STEENSEN VARMING

The below letter provides Steensen Varmings responses to the queries raised in the EPA response to submission. The specific queries have been extracted from the EPA letter and answered directly below.

Sydney June 22, 2018

Appendix A - Proposed Seawater Heat Exchange Infrastructure Options and Information

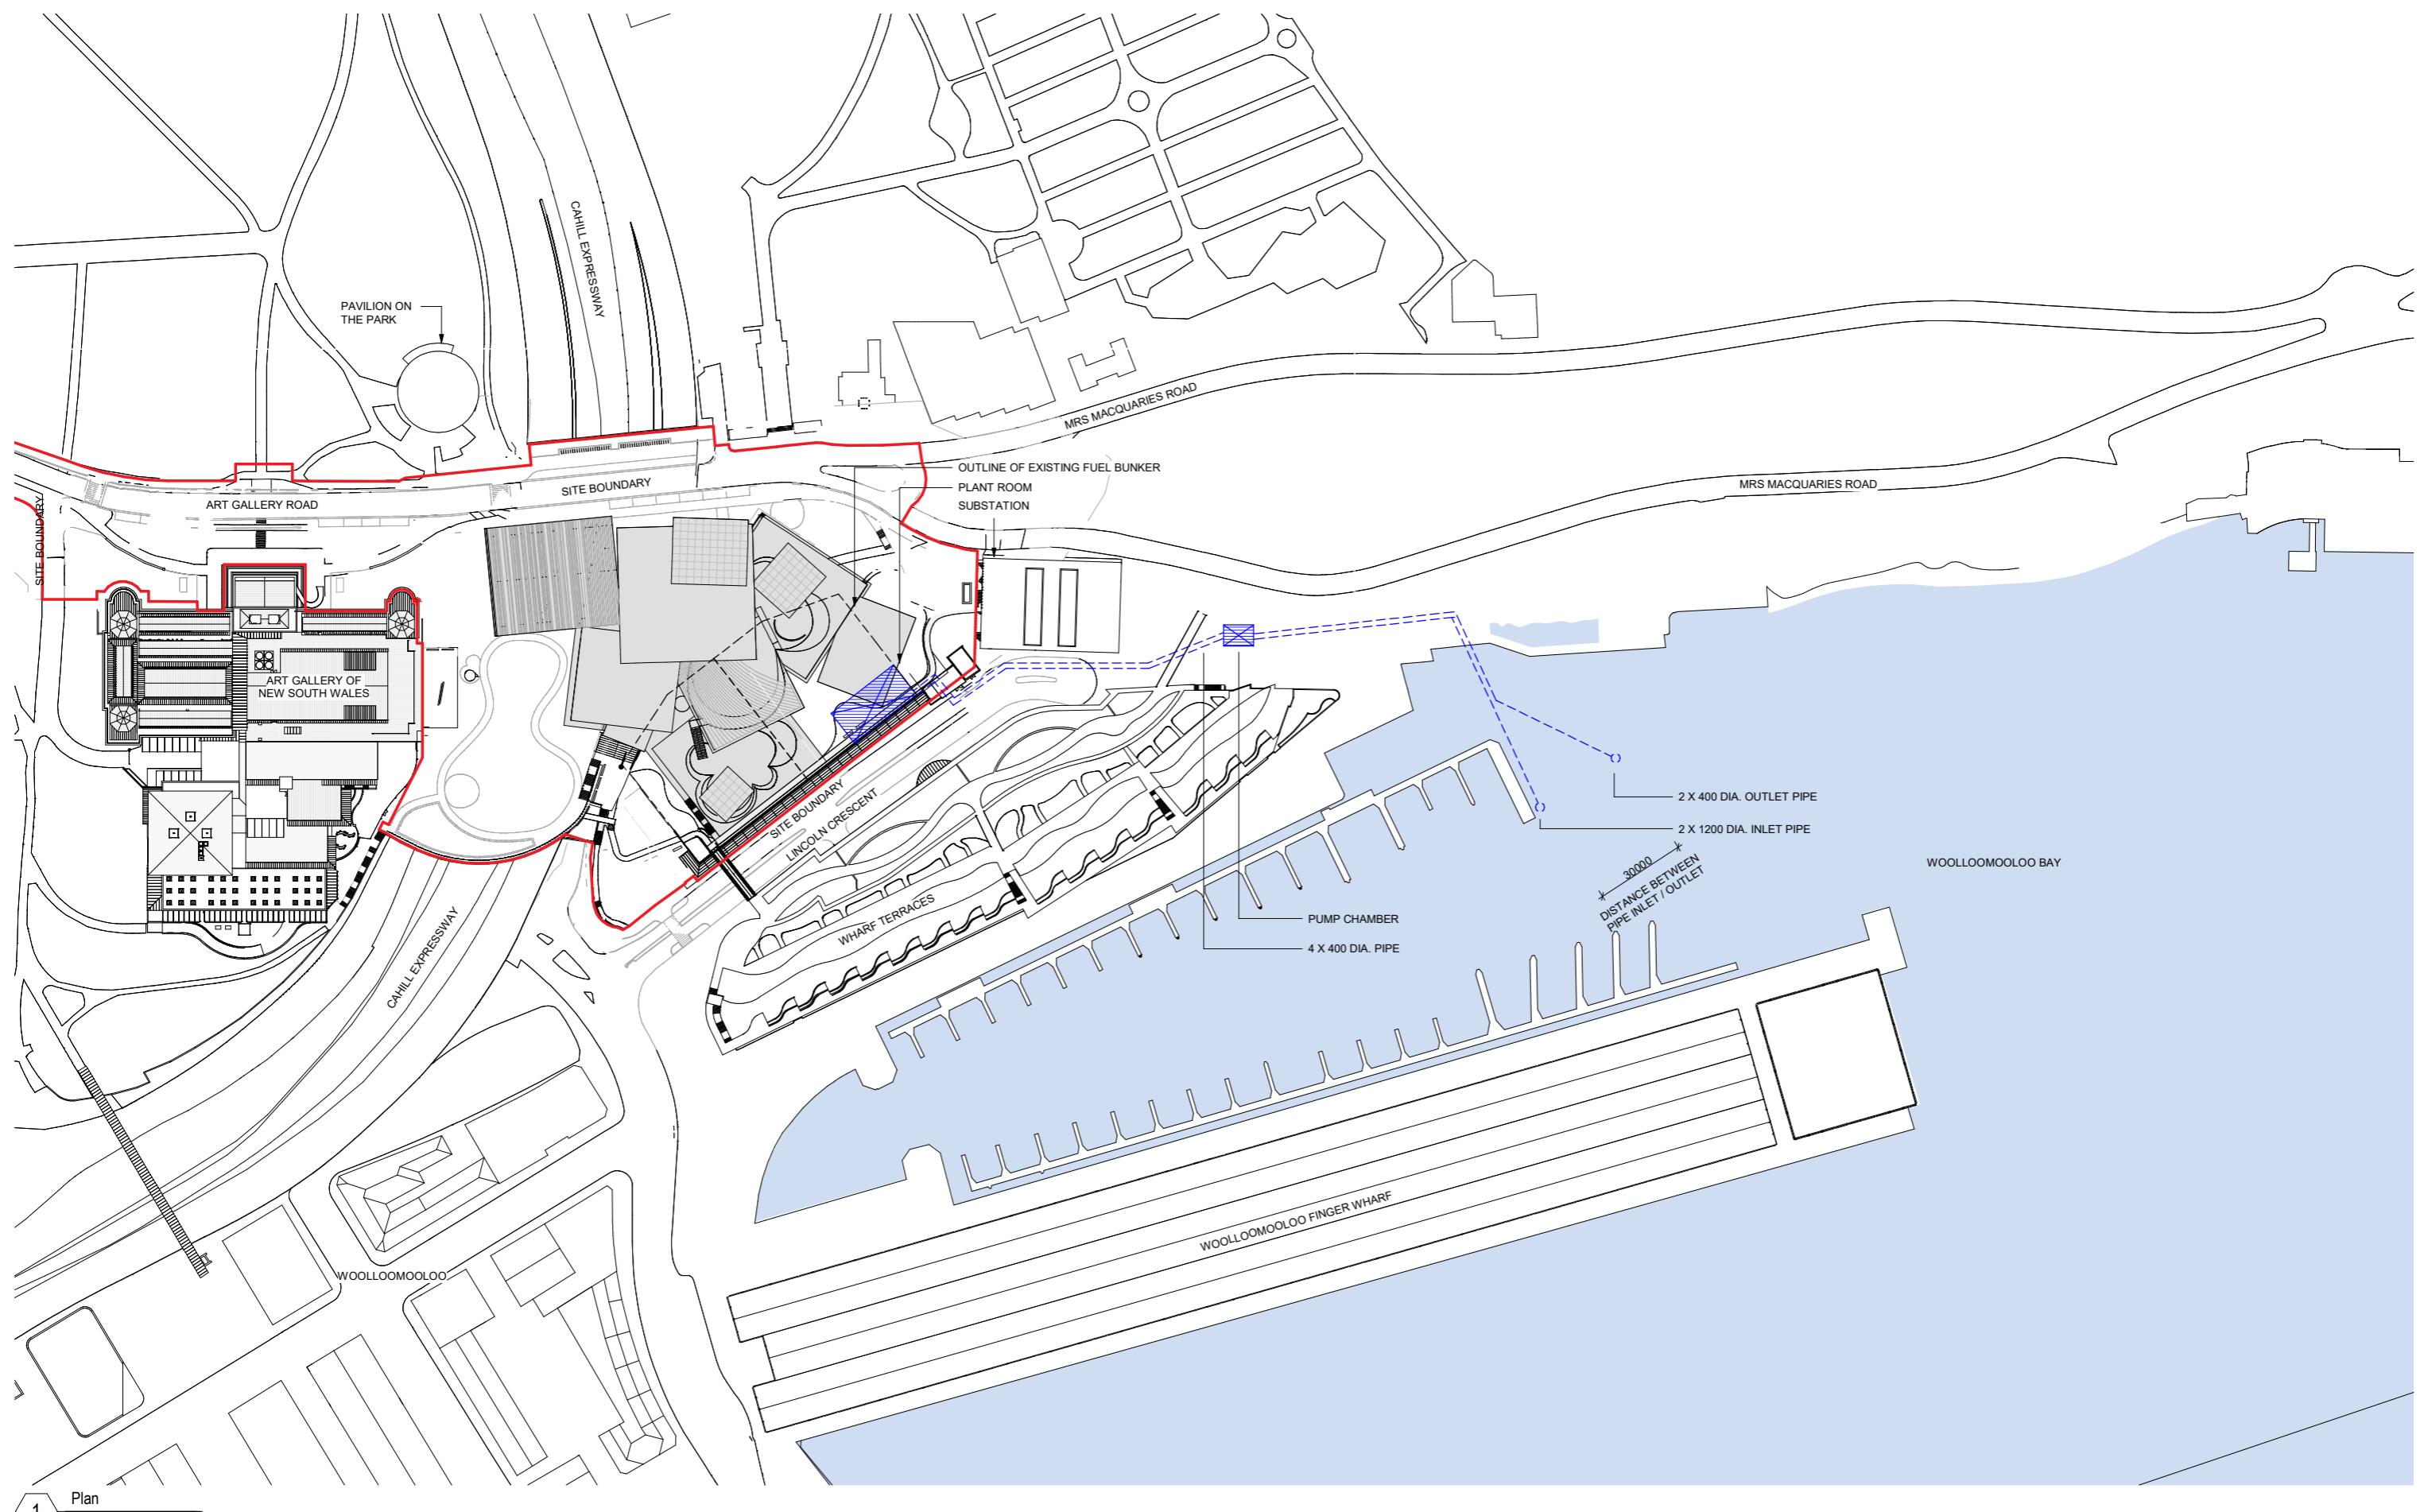
The EPA notes that the design of Seawater Heat Exchange System described in Appendix H to the Report appears different to the design described in the related document accompanying the EIS, including an increase of:

- net heat rejection capacity from 1,600 to 2,600 kilowatts (~60% increase); and
- twin outlet pipe diameter from 300 to 400 millimetres

The EPA notes that the EIS states that the outlet pipe design diameter is 300 millimetres, however the modelling assumes a pipe diameter of 400 millimetres as a worst-case scenario.

The total heat rejection from the system has been calculated at 2366.4kW. To allow for a percentage of future correction, a value of 2600kW was used for calculation purposes. The net rejection given before of 1,600kW was inaccurate based on early estimates.

The sea water return pipe has been designed to have a diameter of 400mm to accommodate the minimum discharge velocity.
